Application Ref:	3/2021/0216	 Ribble Valley Borough Council www.ribblevalley.gov.uk
Date Inspected:	30/03/2021	
Officer:	AB	
DELEGATED ITEM FILE REPORT:		REFUSED

Development Description:	Regularisation of unauthorised summer house within the curtilage of the existing property.
Site Address/Location:	Varleys Farm Anna Lane Bolton by Bowland BB7 4NZ

PROPOSED SITE PLAN (1:500)

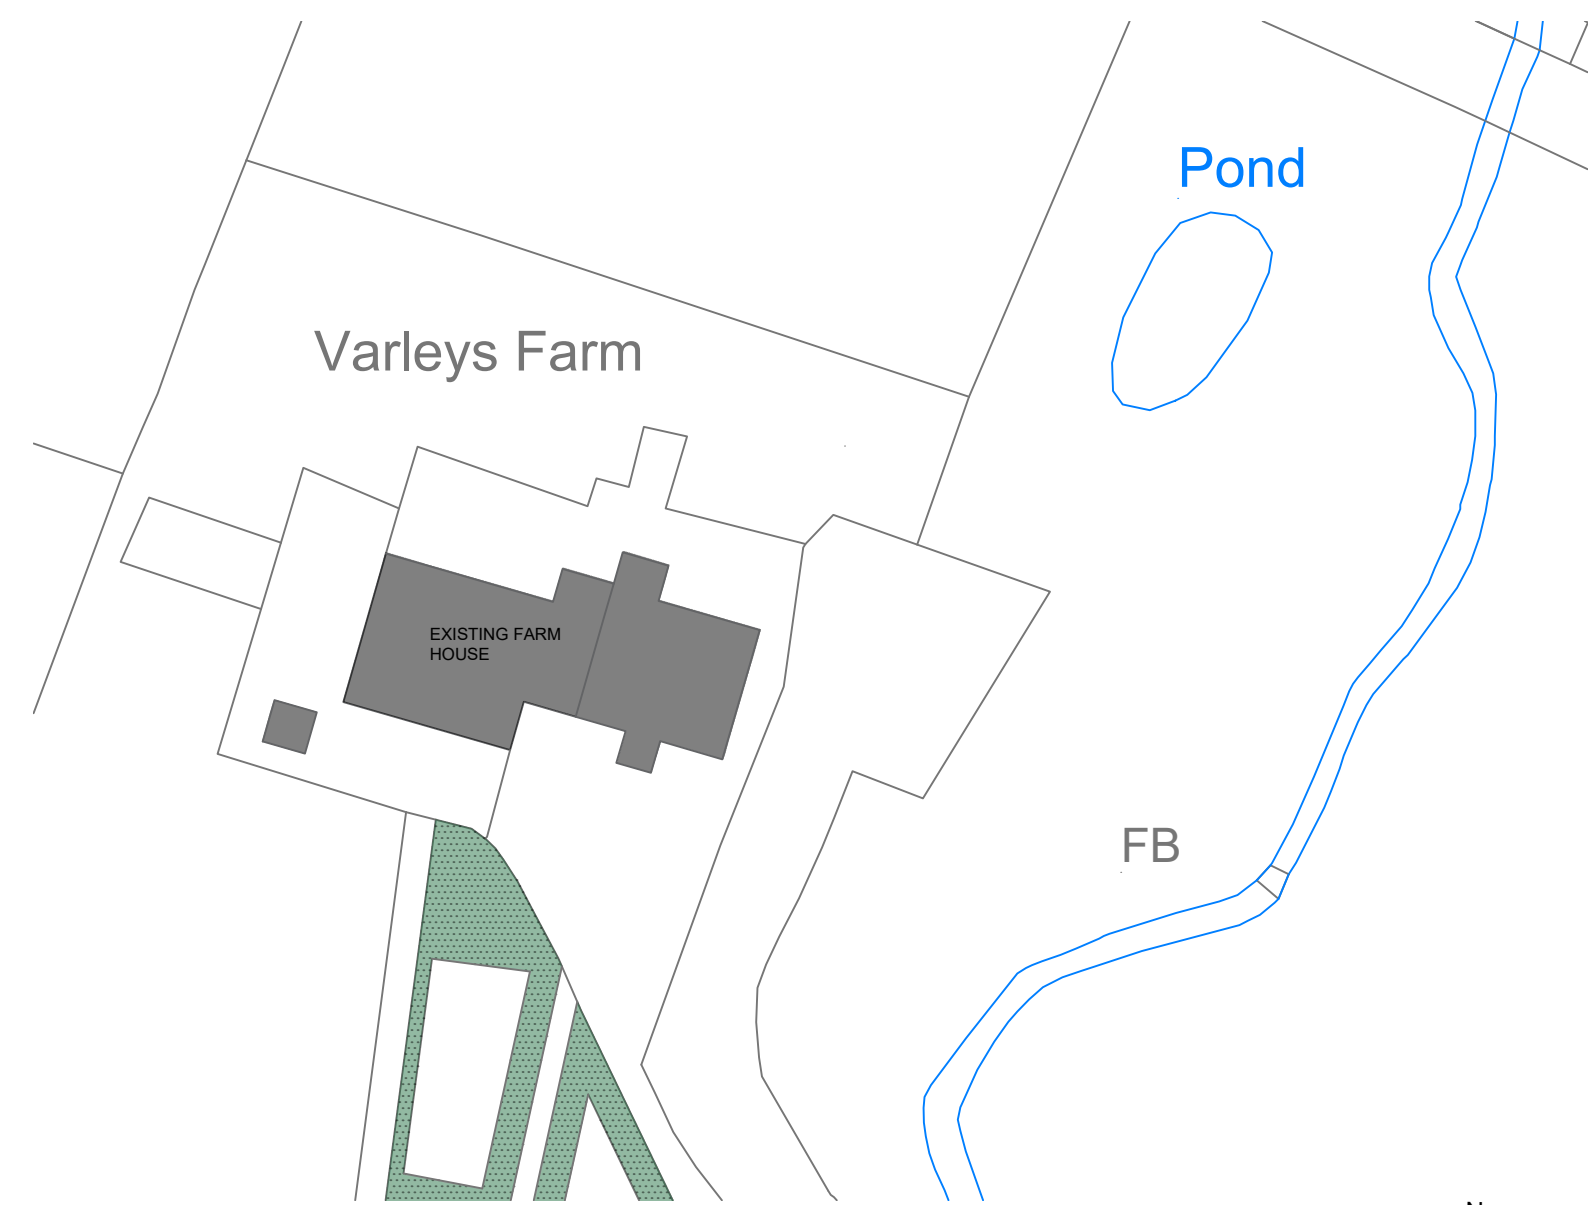
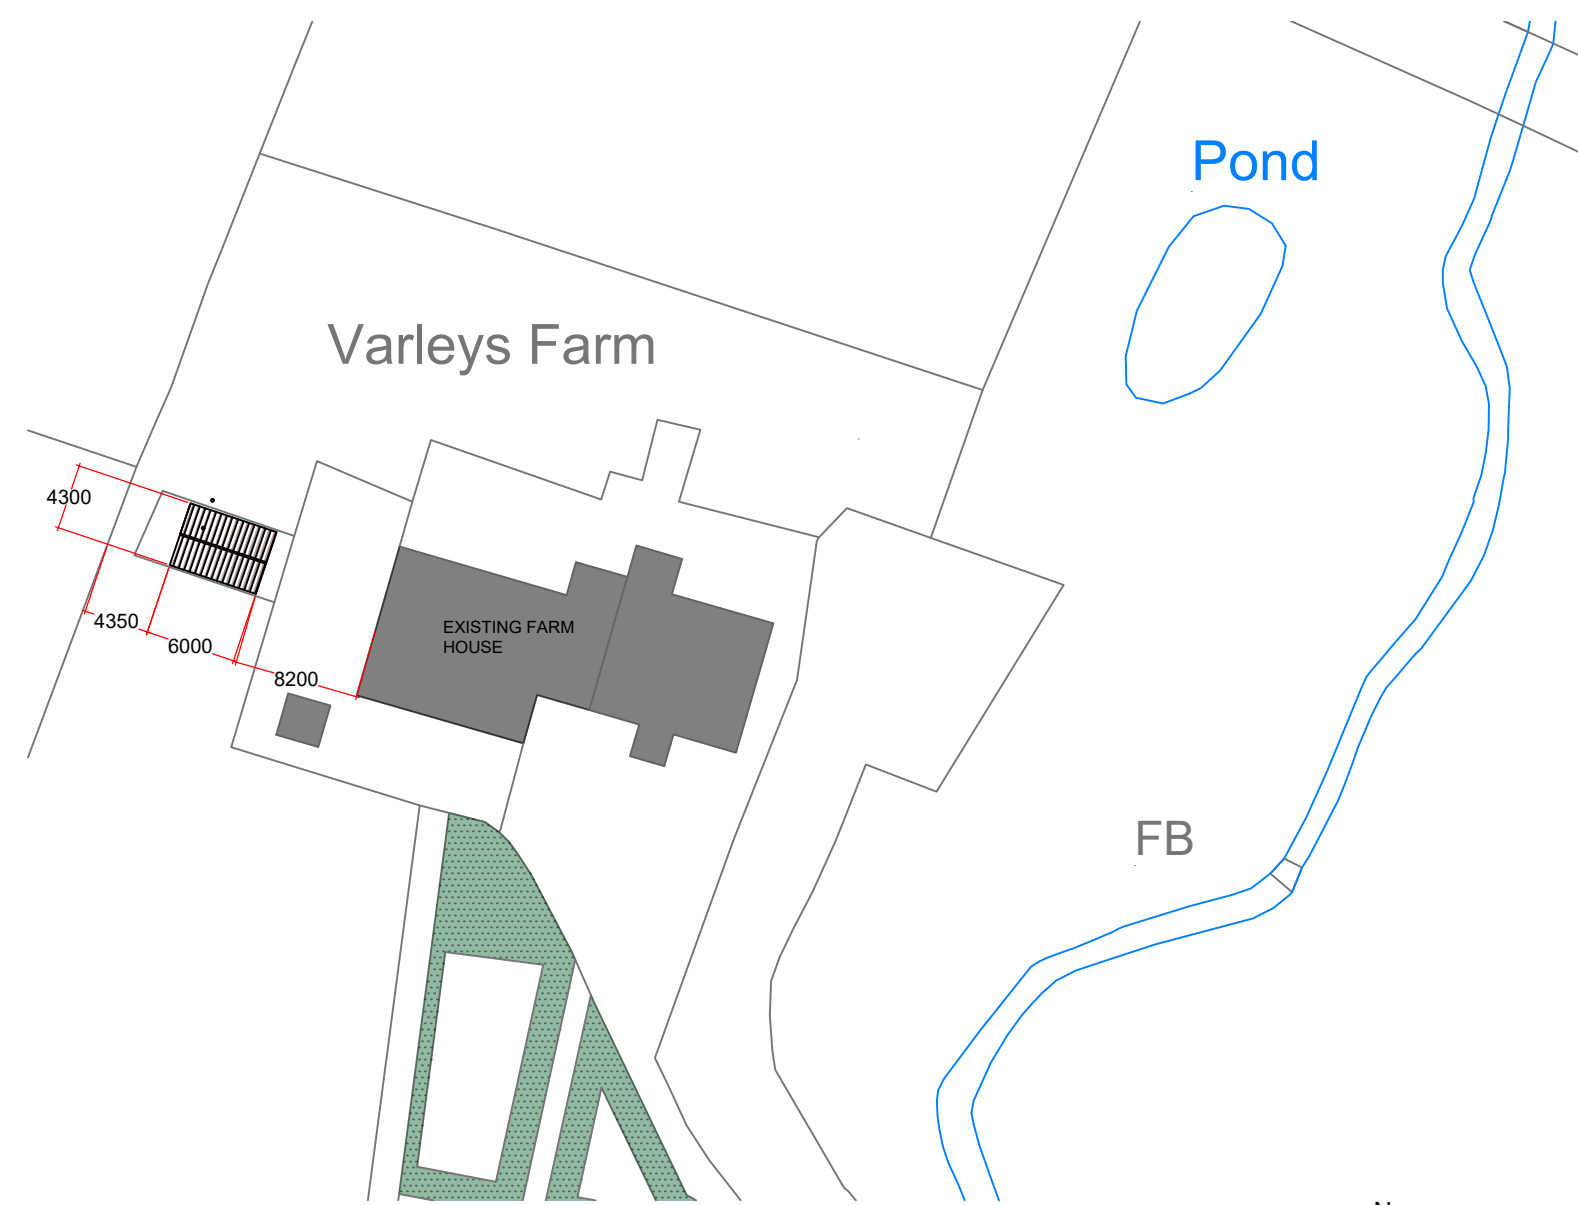
The summerhouse which is the subject of this application is located outside of the approved curtilage boundary. The surrounding land has taken an increasing manicured appearance over the years to the detriment of the setting of the farmhouse and barn, and it is considered that approval of the summerhouse, which includes large patio doors opening onto the land in question, would be taken as indication that residential garden use of a wider area is acceptable.

Google Earth images show that in December 2010, the land beyond the retaining walls surrounding the house remains agricultural in appearance. As such, based on the evidence, regularisation of the building of the summerhouse would also include a change in the use of the land on which it is located and the areas of land beyond this where residential garden use would be facilitated.

Having regard to the above, the summerhouse has been constructed on land beyond the established residential unit, can only be accessed across non-residential land and would also provide direct access to said land, therefore facilitating it unlawful residential use.

PROPOSED EAST ELEVATION (1:50)

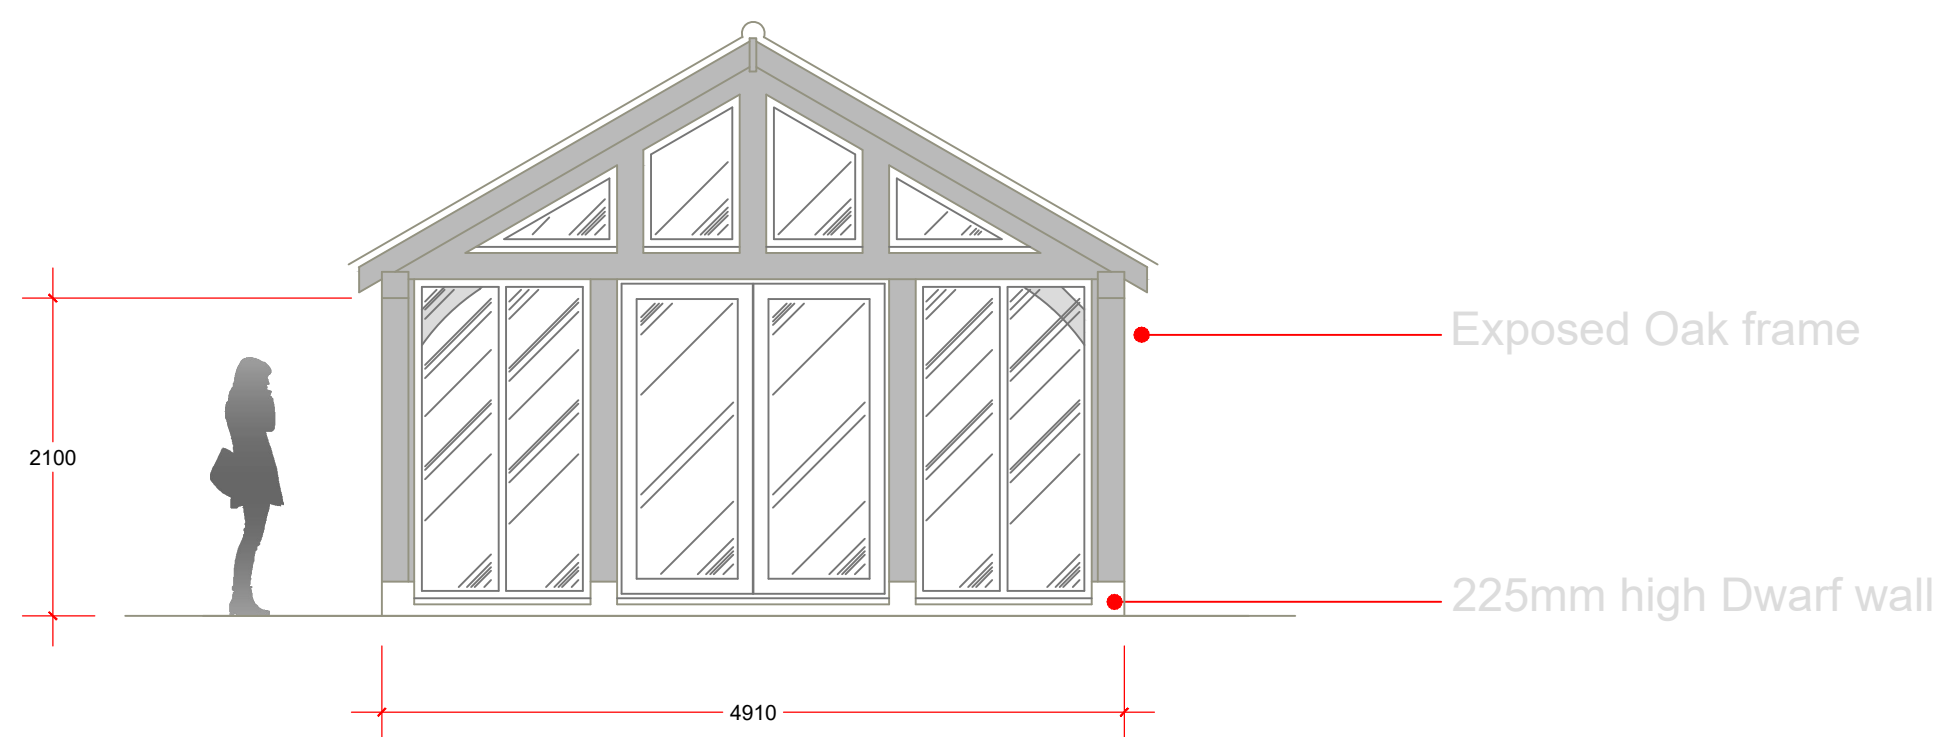
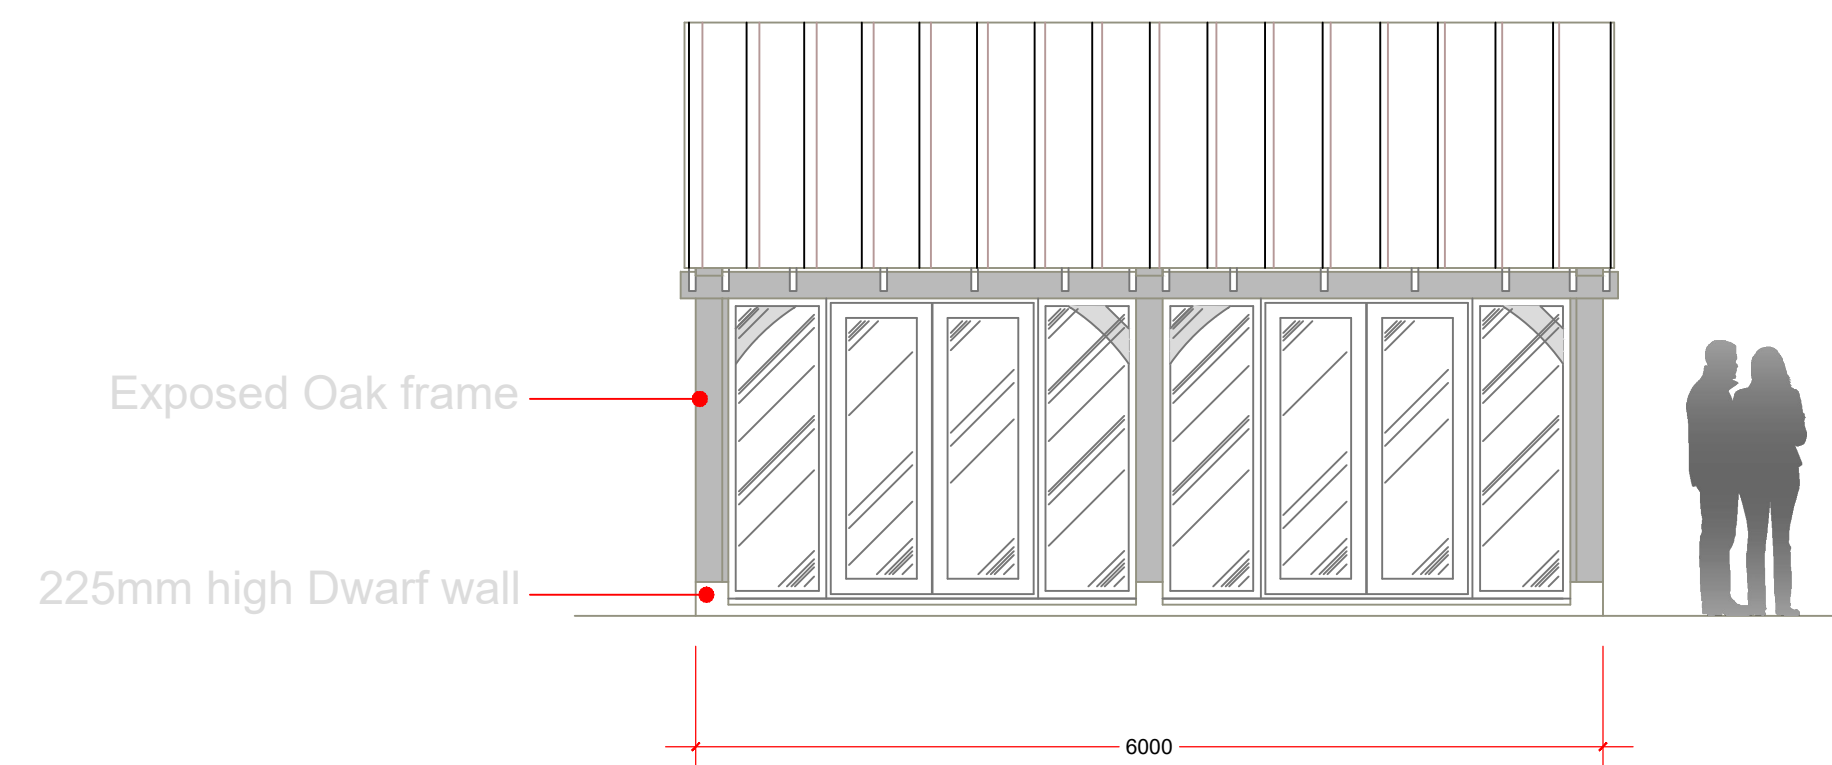
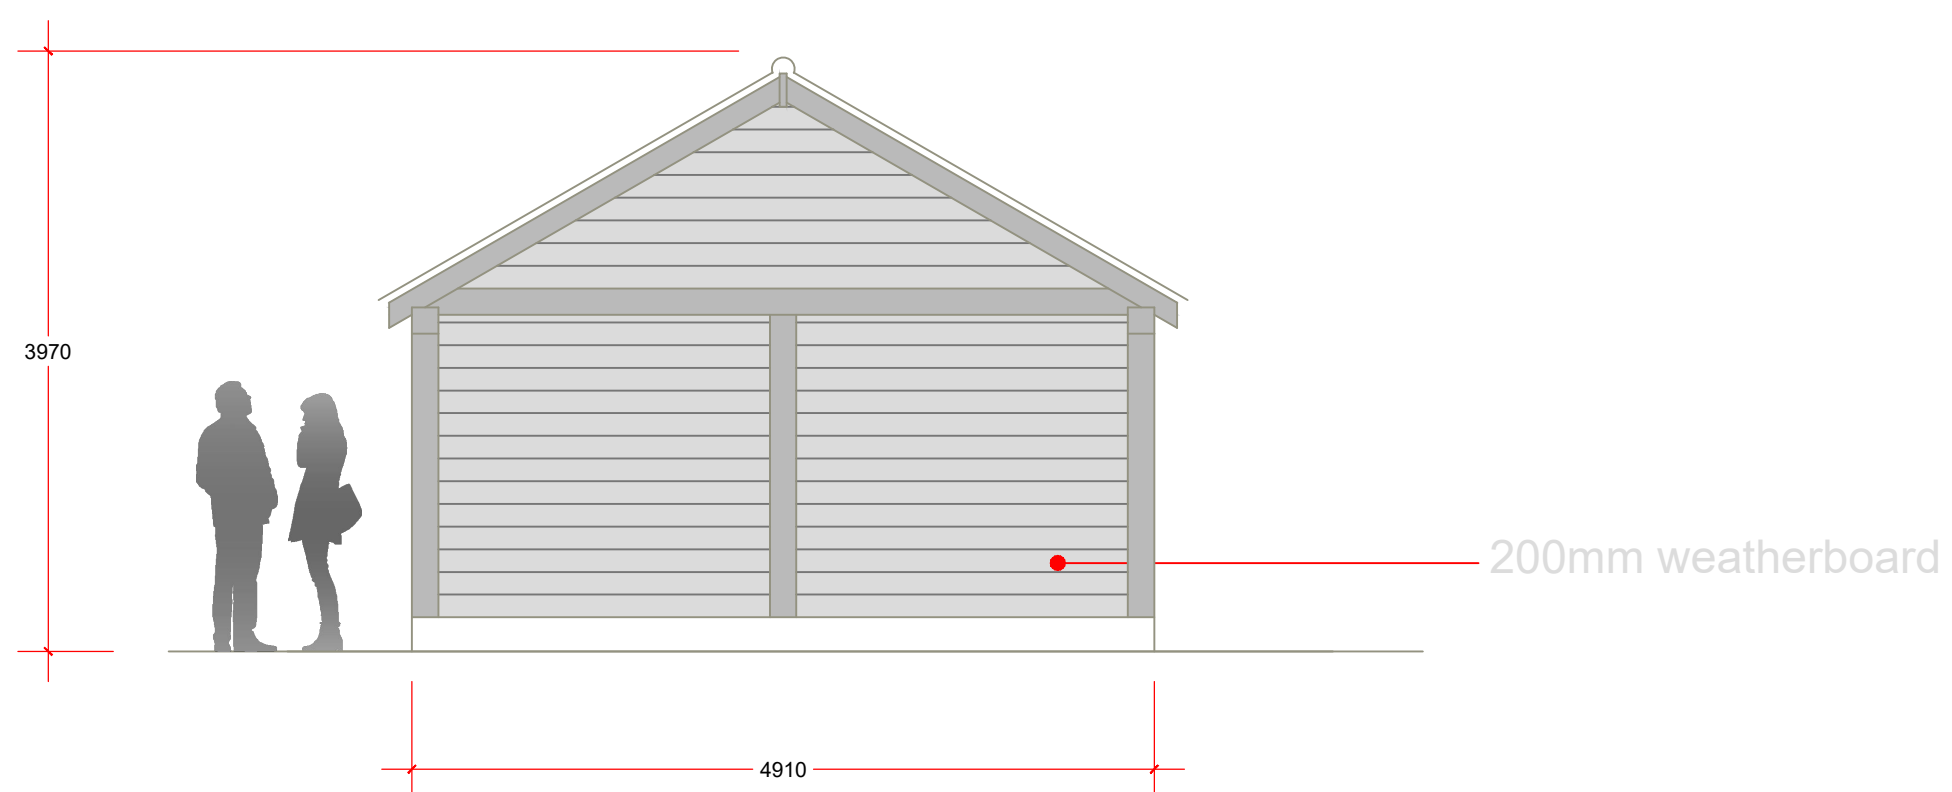
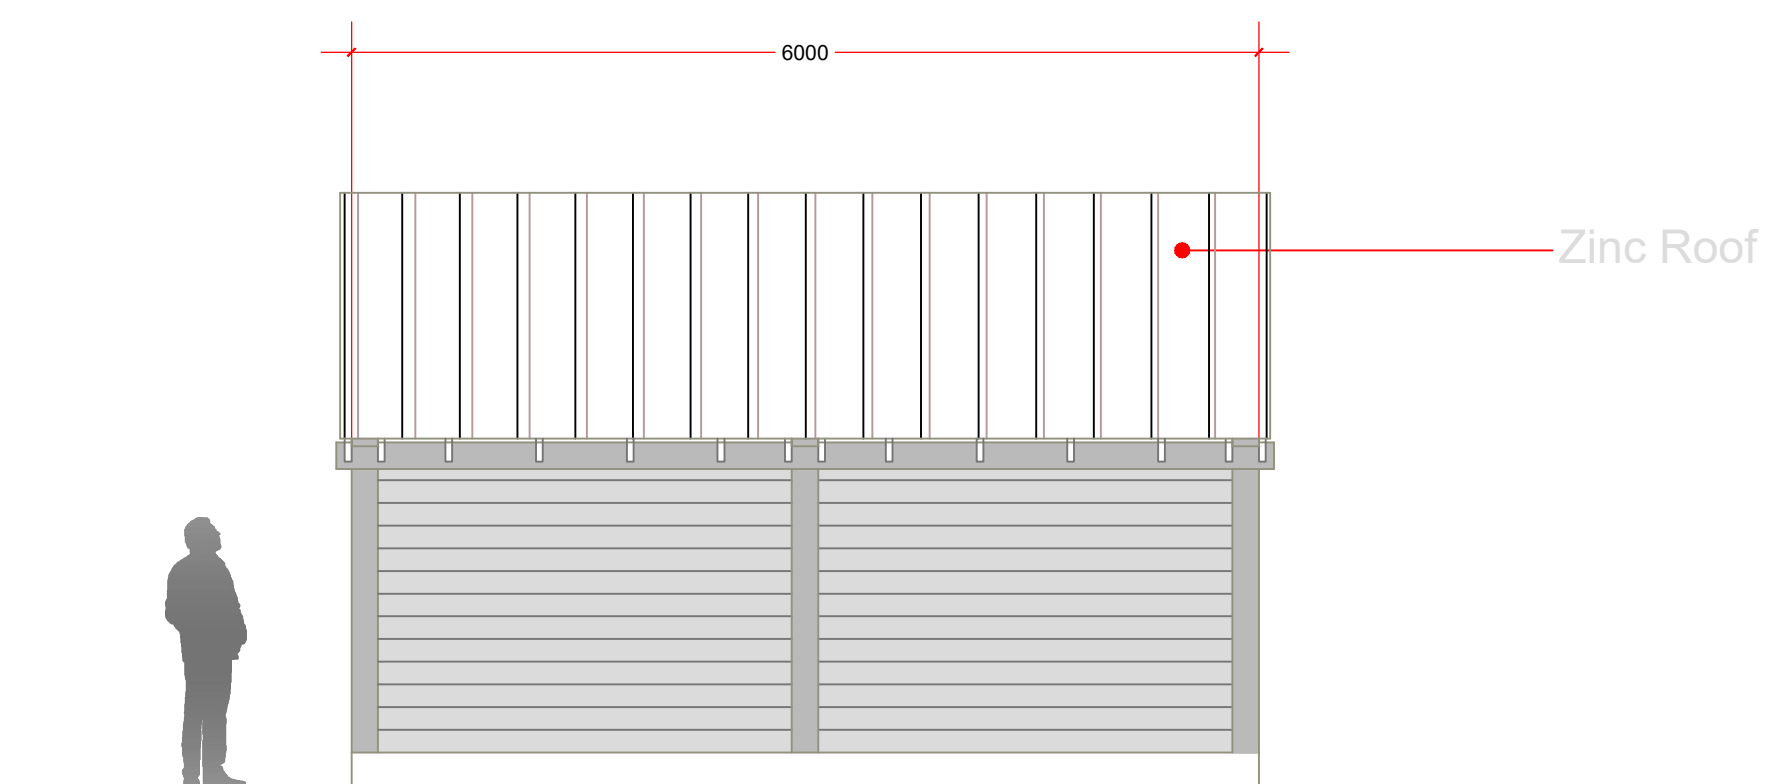
In terms of the summerhouse itself, the building is not significant in size or scale. However, it is a prominent addition as a result of its raised position. Given its prominence and its failure to respect the inherent character of the main building, it is considered to be harmful to the character and appearance of the main dwelling.
